**COLORADO**  
**Department of Transportation**  
Region 2

RE: SP 215 - Viewpoint Estates - Preliminary Plan (Minor)

I am in receipt of a referral request for comment for Viewpoint Estates Filing No 2 Preliminary Plan located at 21209/21307 Chesley Drive, in the Town of Calhan, El Paso County, State of Colorado. State Highway 94A (Category NR-A) is the southern boundary of the site. The area of land under consideration for vacating and replating is  $\pm 24.33$  acres. Approval will generate the vacating and replating lots 71 & 72, into seven (7) single family rural residential lots. **Access to the lots in the subdivision will be from Chelsey Drive connecting to Colorado Highway 94 via existing Antelope Drive which is constructed with asphalt surface and roadside ditches.** The property is Lot 71 and lot 72 of Viewpoint Estates as recorded in El Paso County, under reception number 99189220. After review of documentation, we have the following comments:

**PRELIMINARY PLAN  
VIEWPOINT ESTATES  
FILING NO. 2**

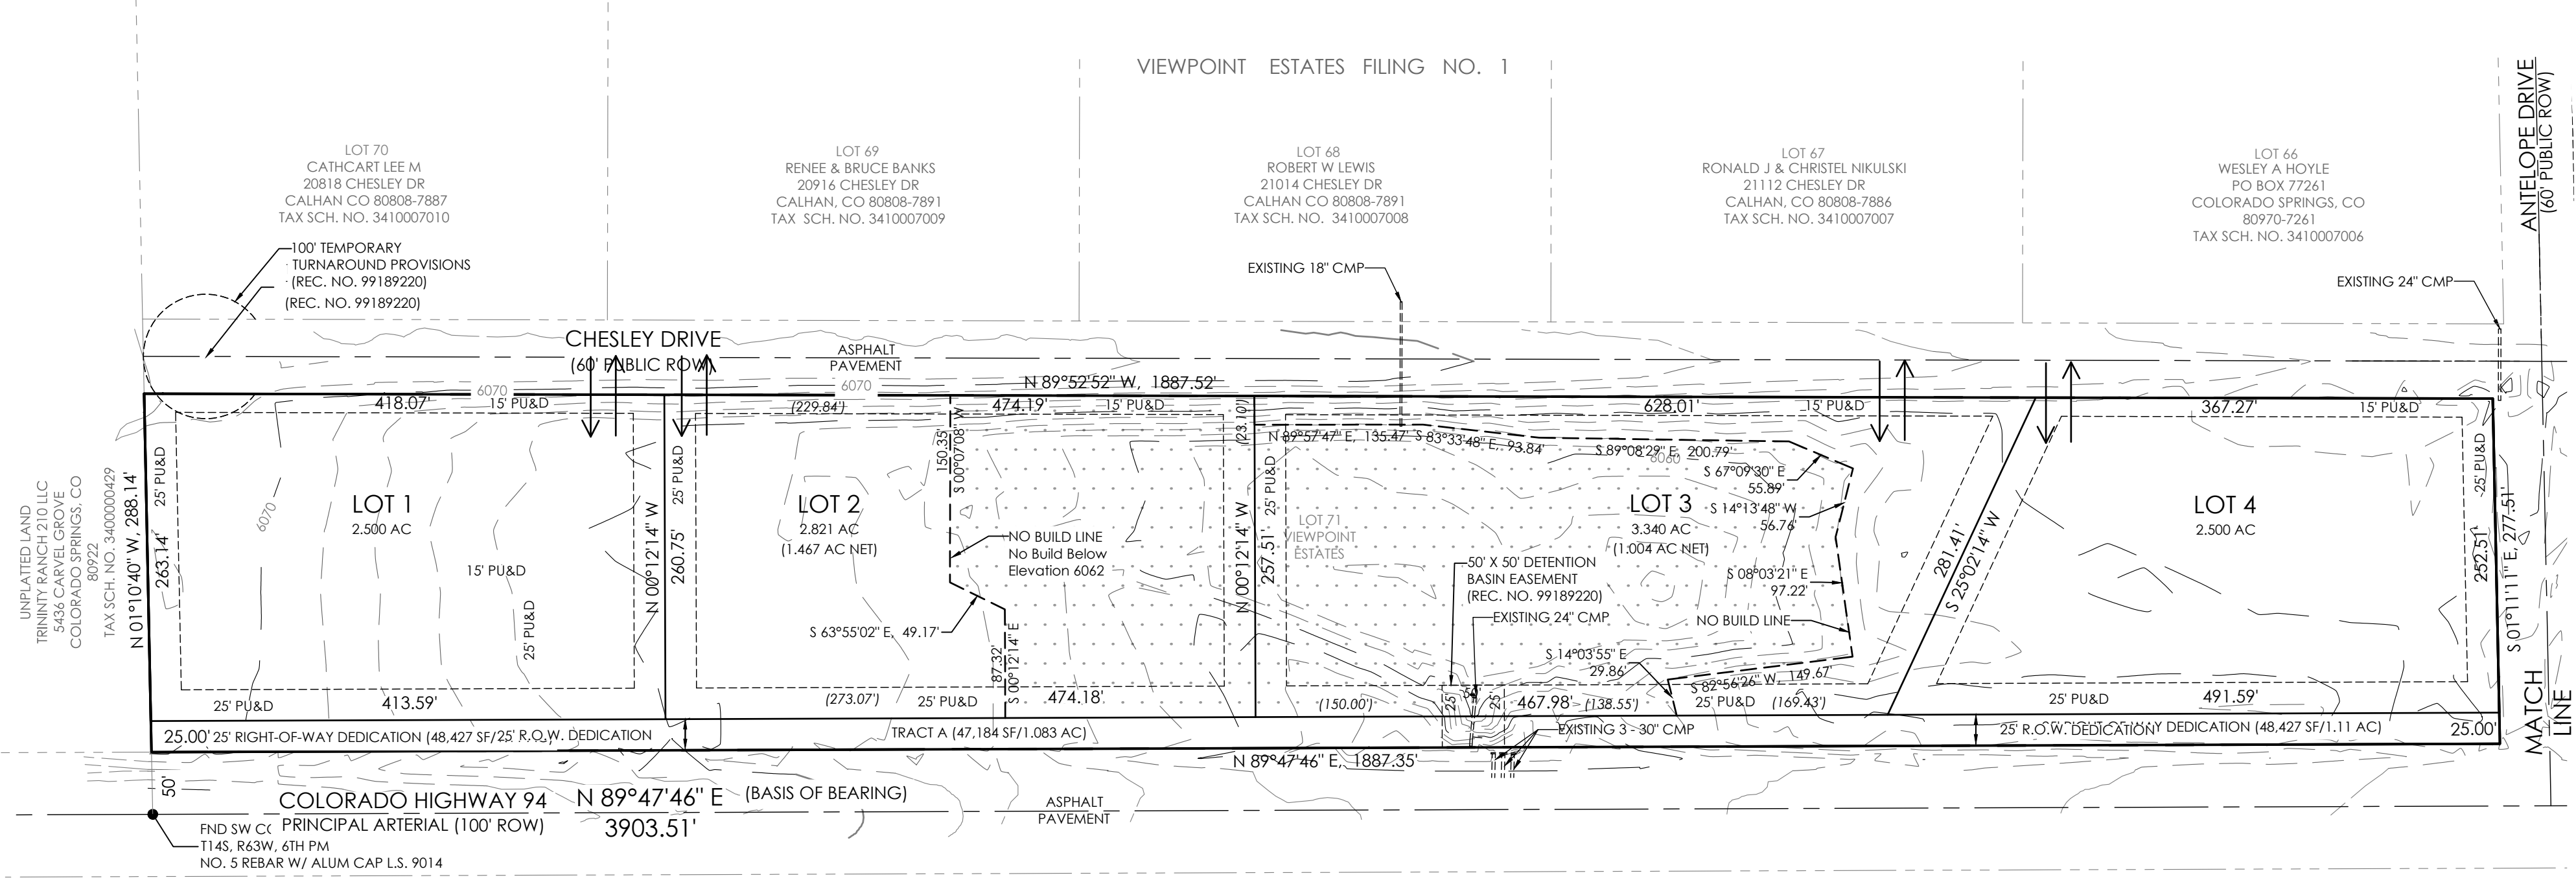
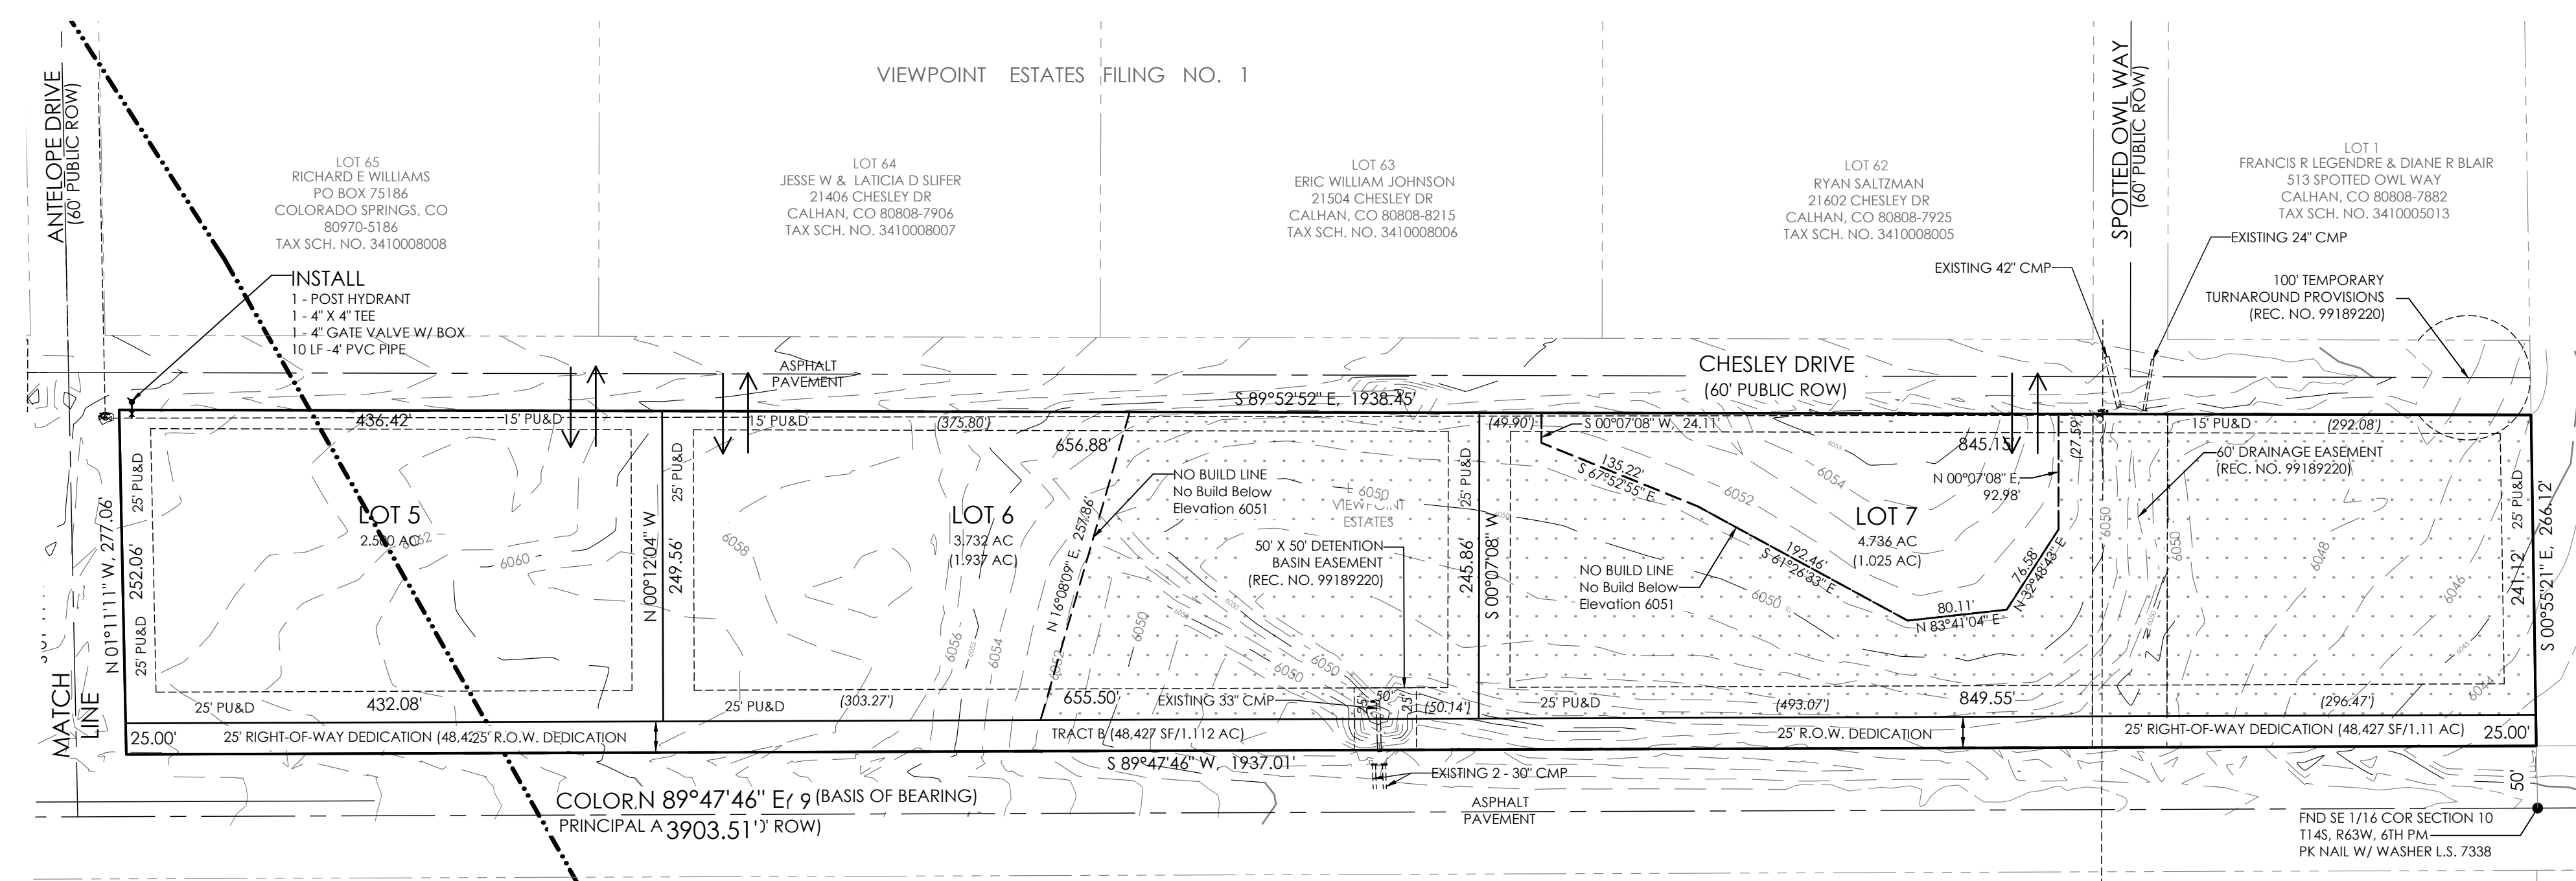
- Access will remain for CDOT crews to access the culvert under SH 94. Any necessary remaining easement lines will be addressed by others.
